# Consultee Comment for planning application 6/2018/2387/MAJ

| <b>Proposal</b>           | <input type="text" value="Construction of new build of 22 x 2 Bedroom and 2 x 3 Bedroom residential apartments with balconies and a roof garden. Layout of 26 car parking spaces, cycle parking, refuse store, internal access routes, landscaping and supporting infrastructure."/>   |
| <b>Organisation</b>       | <input type="text" value="WHBC - Client Services"/>  |

Drawing title: PROPOSED SITE PLAN

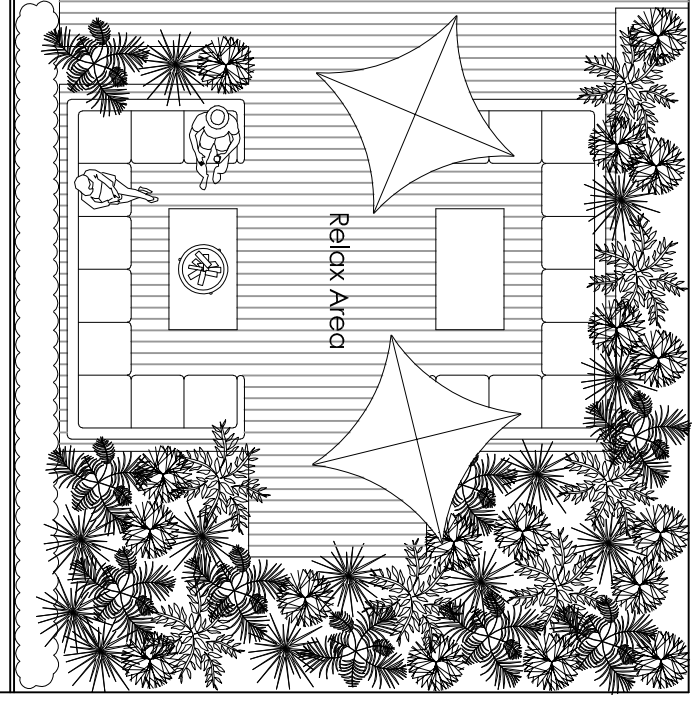
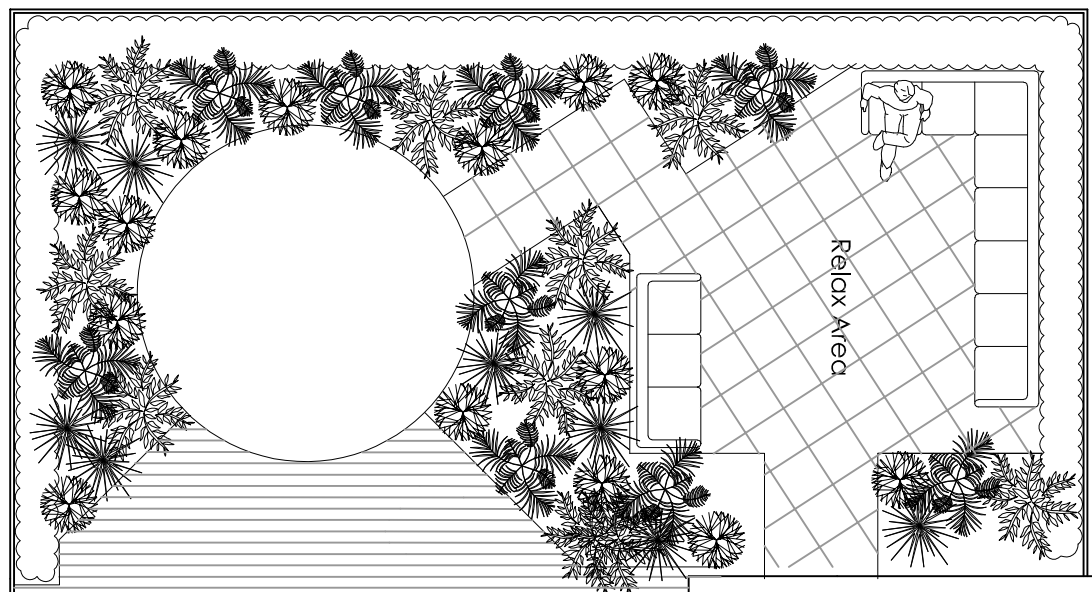
| <b>Comments</b>           | <input type="text" value="04/10/2018 - Lorraine Davis This can be incorporated on to our existing refuse &amp; recycling schedules. As advised on previous application (6/2018/0642/VAR) 4 x 1100l containers would be required at a cost of ?390 each. The bin store will require double doors opening outwards and a clear path with even surface and no kerbs to negotiate. Subsequent tracking diagram on previous application addressed these requests to our satisfaction If the developers wish to provide recycling facilities a Mini Recycling Centre can be installed within the bin store and this would accept glass/can and paper. the cost of this would be ?560.00. The dimensions of all containers and MRC are on our Bin Store Planning Guidance attached here."/> |
